23rd May 2019

**Erection of 2 No. 3 Bed Dwellings with off road parking and associated landscaping
Land at Entrance to Waterford Gardens, Horsemere Green Lane, Climping, BN17 5PQ
Planning Reference CM/18/19/PL. Case Officer Mr Z Denton**

drawing title:
Site Plan

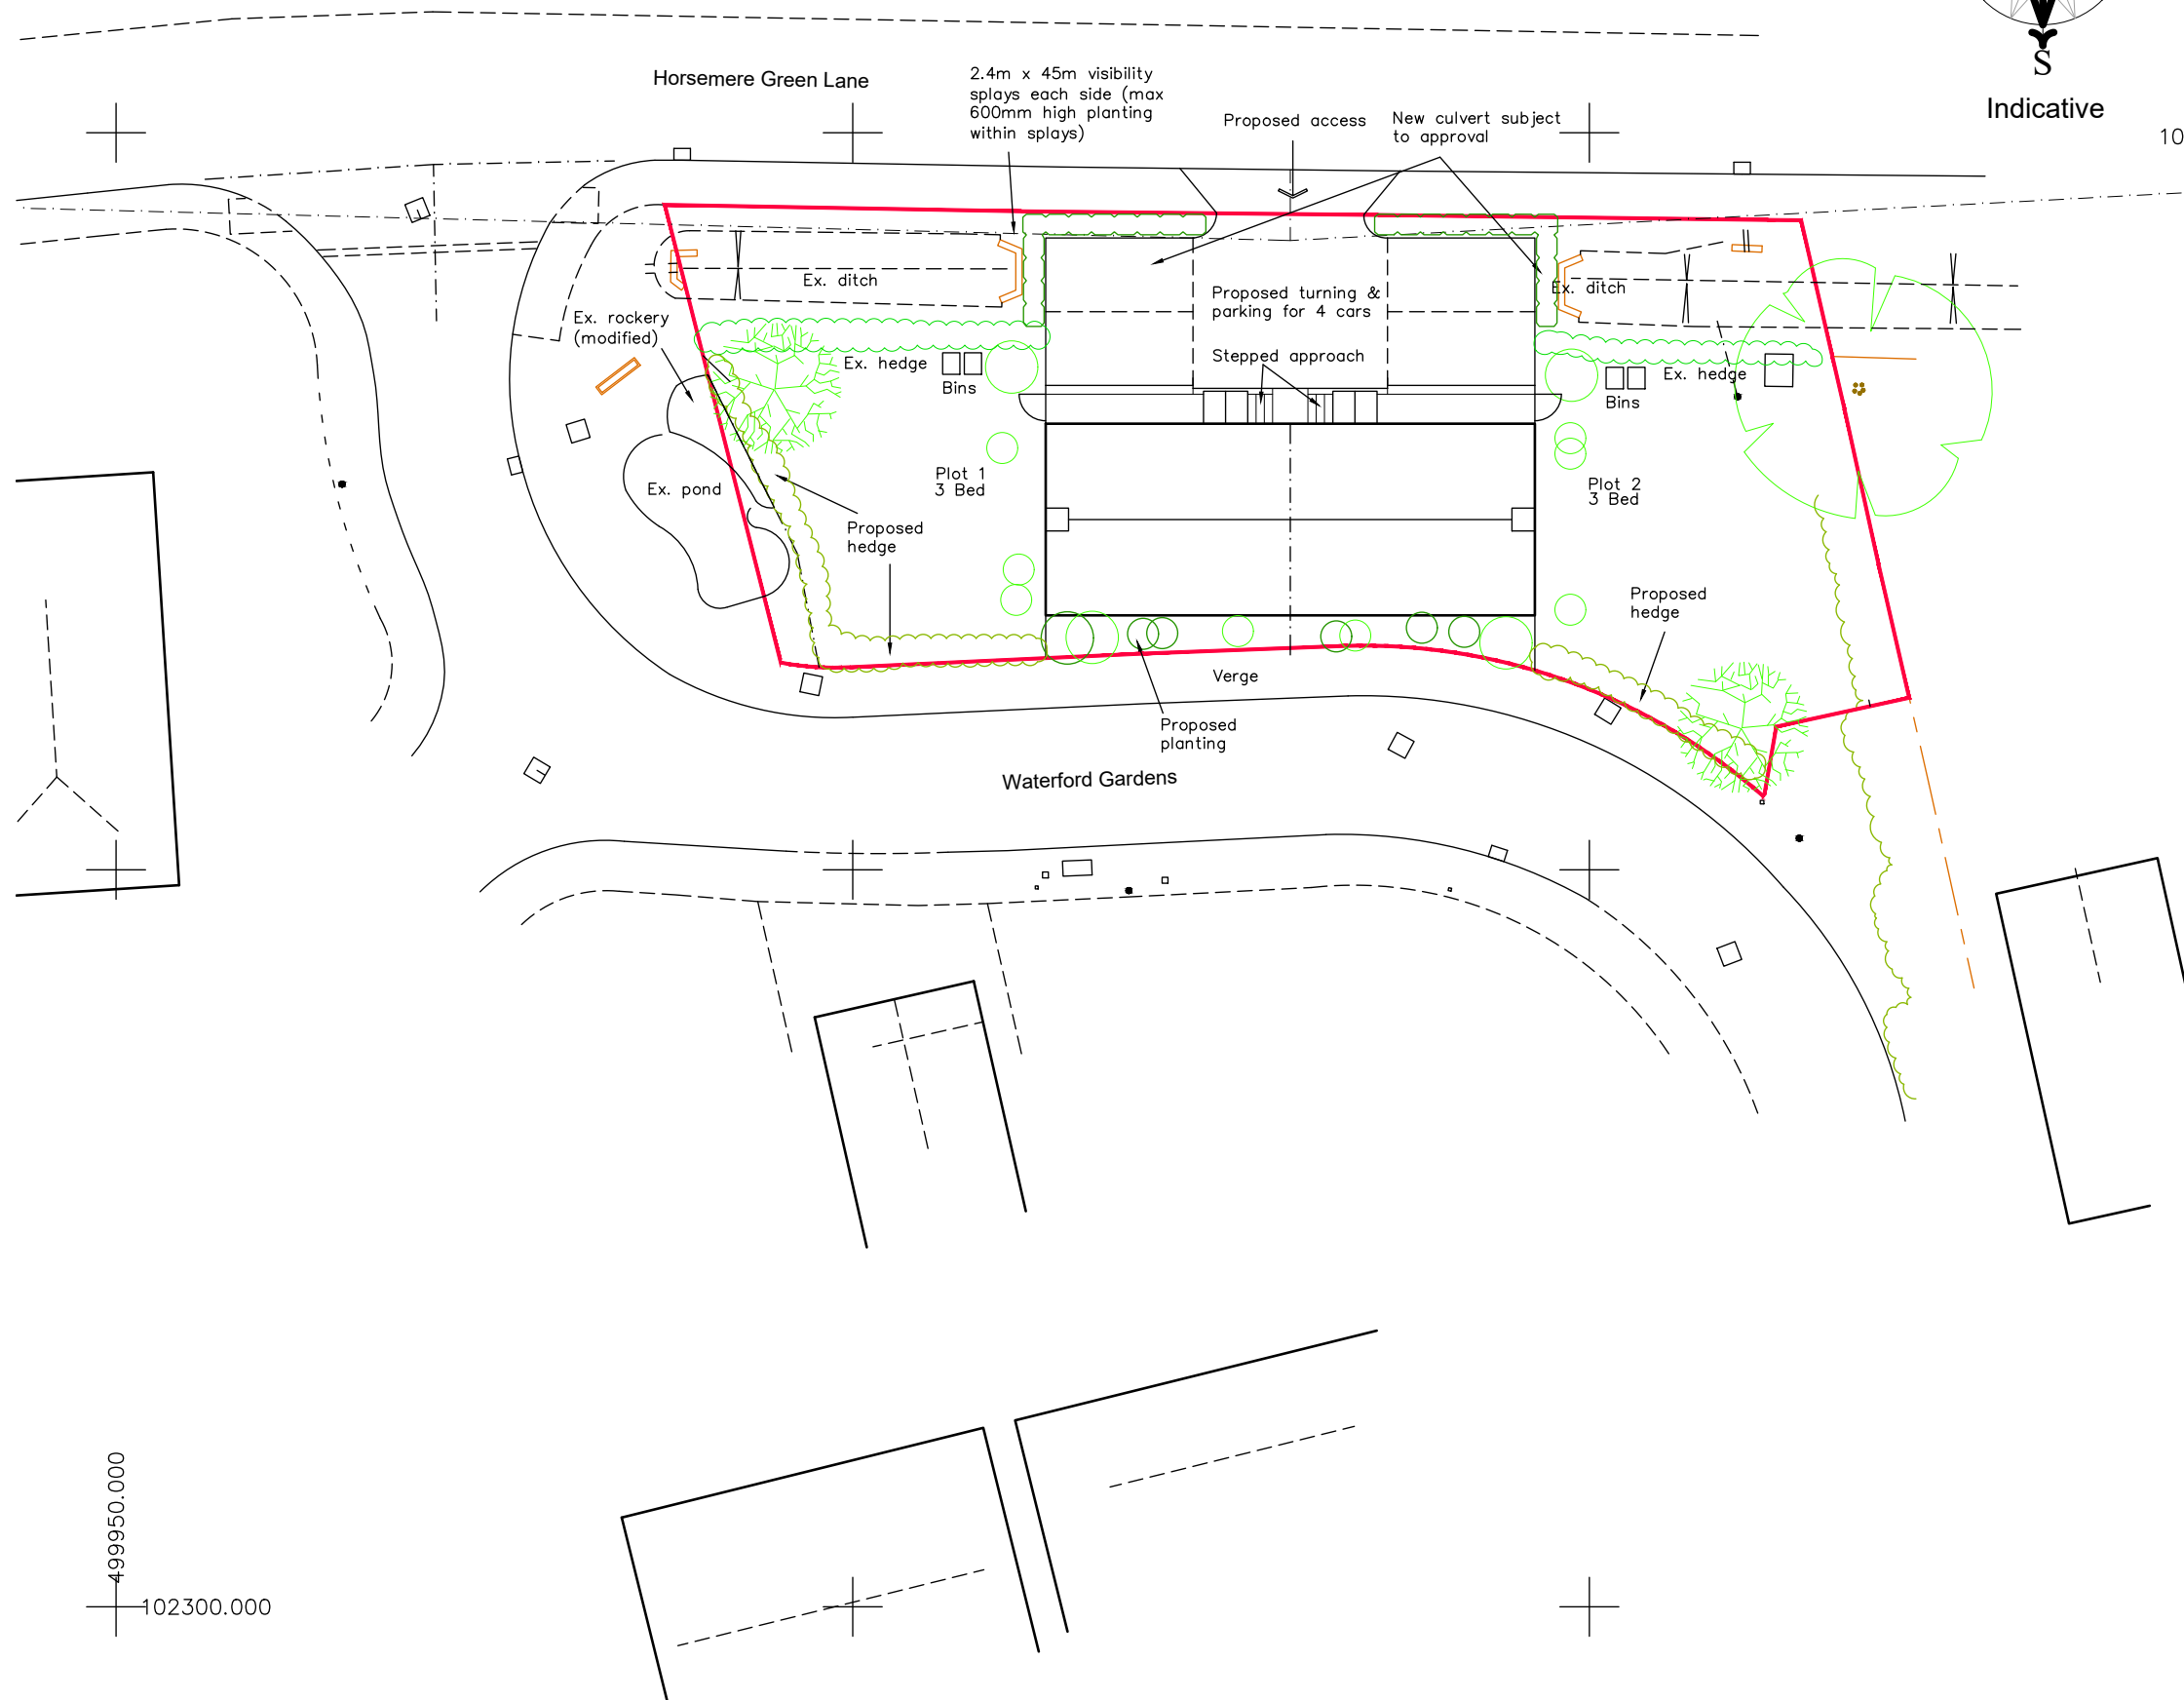
- 6) ADP Architects Drawing 1769/10/B indicates 2.4m x 45m visibility splays each side (max 600mm high planting within splay), how are these going to be constructed as they are on Land not owned or in the control of the Developer. Again, this is a false illustration and is highly misleading to the Planning Authority.

- 8) ADP Architects Drawing 1769/10/B indicates Soft Landscaping and Hedging, but we highlight none of the Existing Planting, Hedges, Bushes, Trees and or their roots on the Boundary of the Development Site with the Boundary of 29 Crophorne Drive are currently maintained by the Developer and are all overgrown to the point where fencing is being damaged so we question how the Developer will plant and maintain any Soft Landscaping and Planting as no actual maintenance or maintenance plan is currently in place.

Proposed Elevations

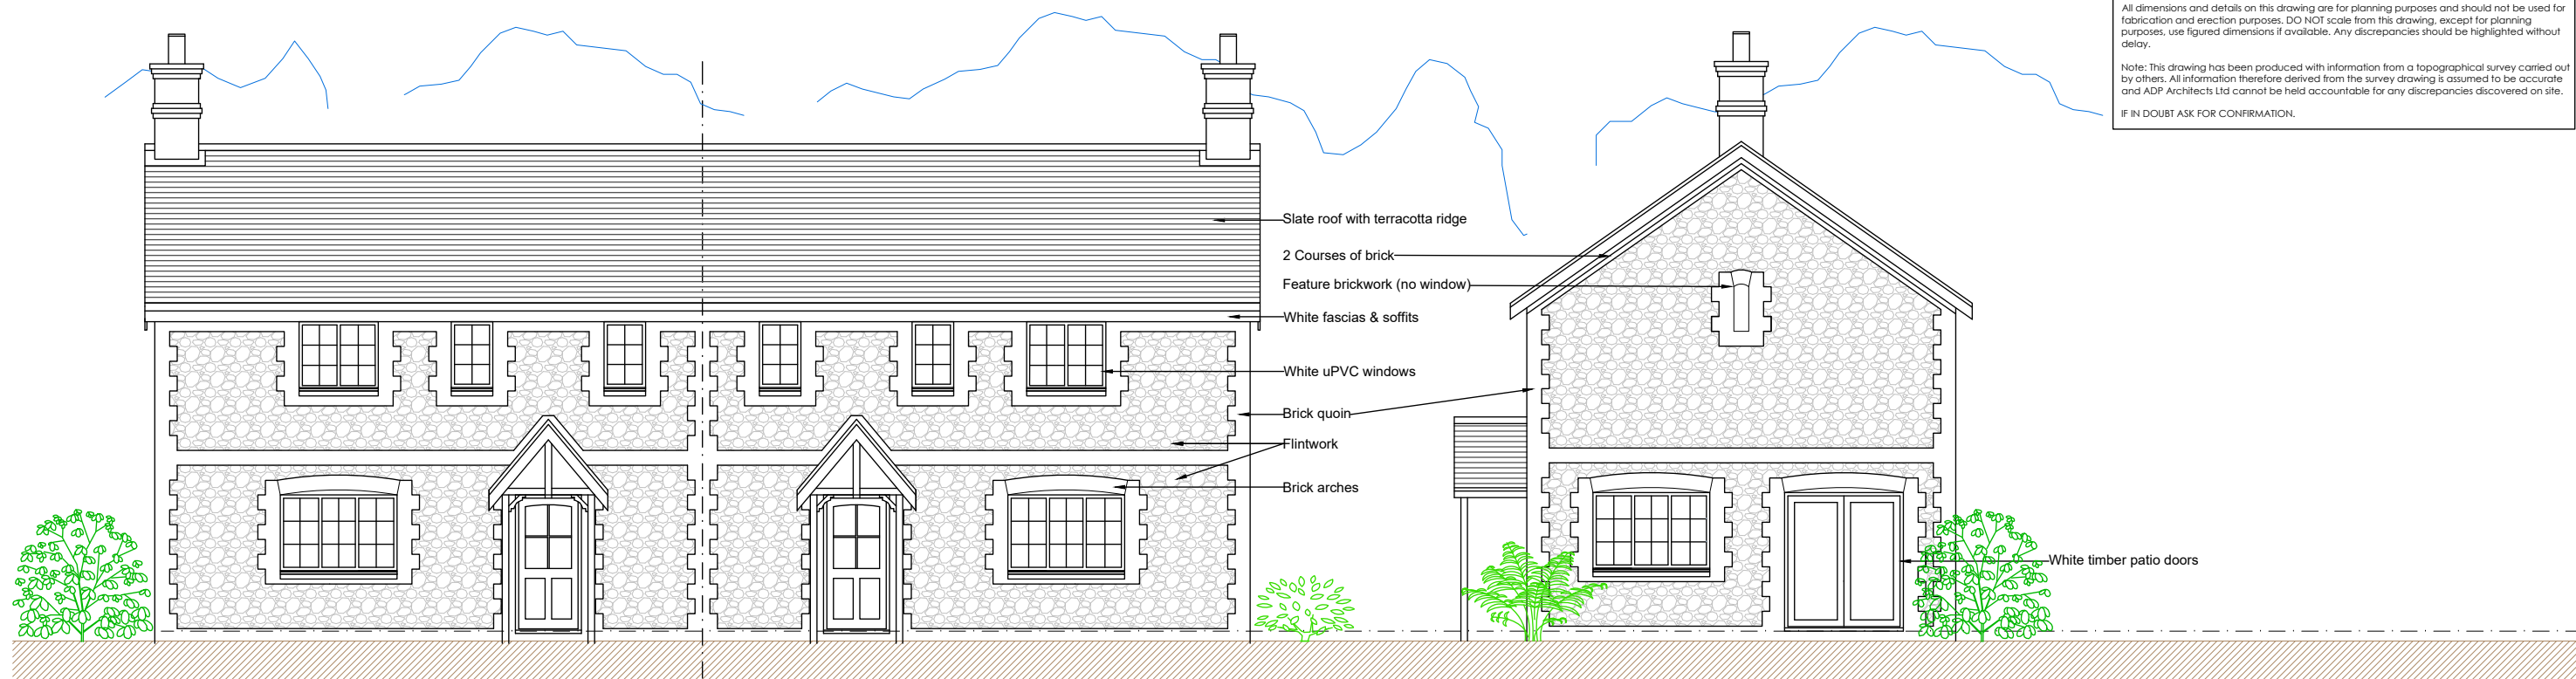
- 9) ADP Architects Drawing 1769/12/D includes no levels or heights of buildings and chimneys.
- 10) ADP Architects Drawing 1769/12/D makes no reference to Obscure Windows to Bathrooms or Windows that directly overlook other properties.

TITLE Existing Site Layout	
SCALE 1:200	PROJECT No. 23078
REPORT TYPE DS	DWG. No. 02

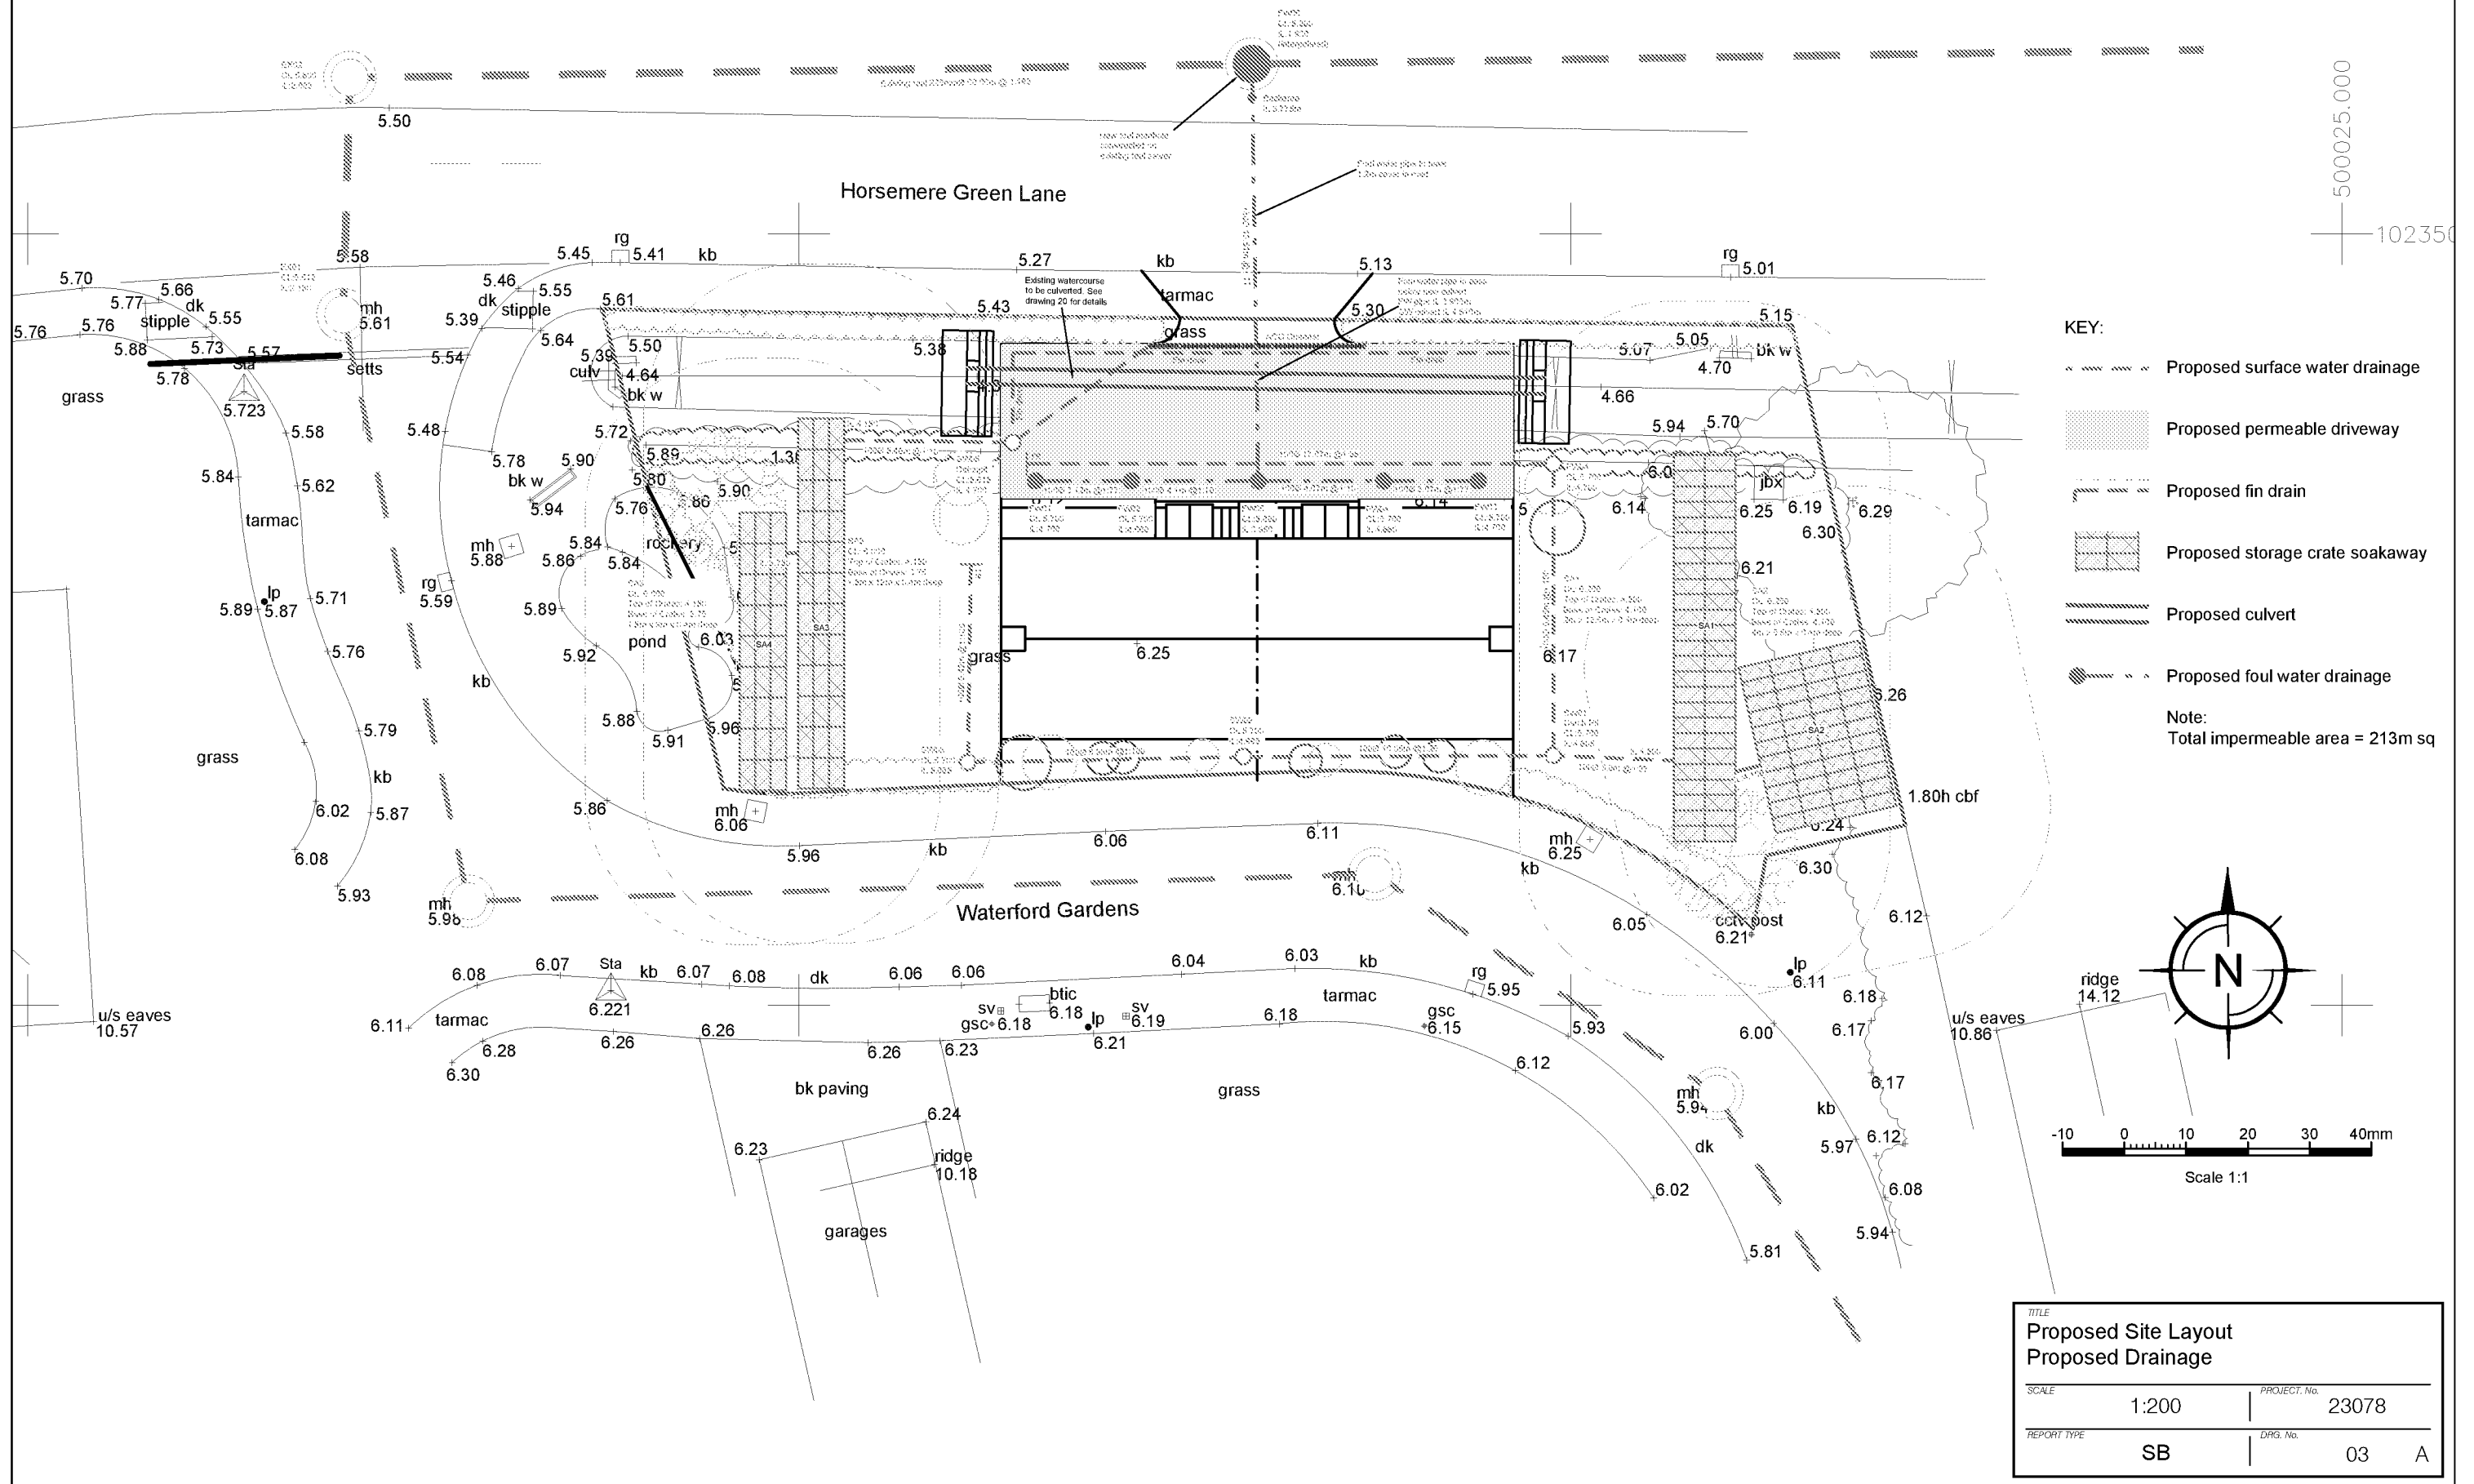
- 3) Planning Application CM18/19/PL does not include any Ground Investigation or Soil Report.
- 4) The Civil Engineering Practice Drawing 23078/03/A appears to indicate the whole Development Site and Parking being built past the Existing Boundary Fence and Hedge up to the Public Footpath on Horsemere Green Lane which is on Land not owned or in the control of the Developer. This is a false illustration and is highly misleading to the Planning Authority.

- 5) The Civil Engineering Practice Drawing 23078/03/A indicates Drainage Storage Crates being installed immediately adjacent and on the Boundary of 29 Crophorne Drive which will undermine and affect existing land, structures, fencing and planting owned by 29 Crophorne Drive.

- 11) The Civil Engineer Practice Drawing 23078/03/A refers to 'Existing Watercourse to be Culverted. See Drawing 20 for detail' and yet Drawing 20 is missing from the Planning Application.
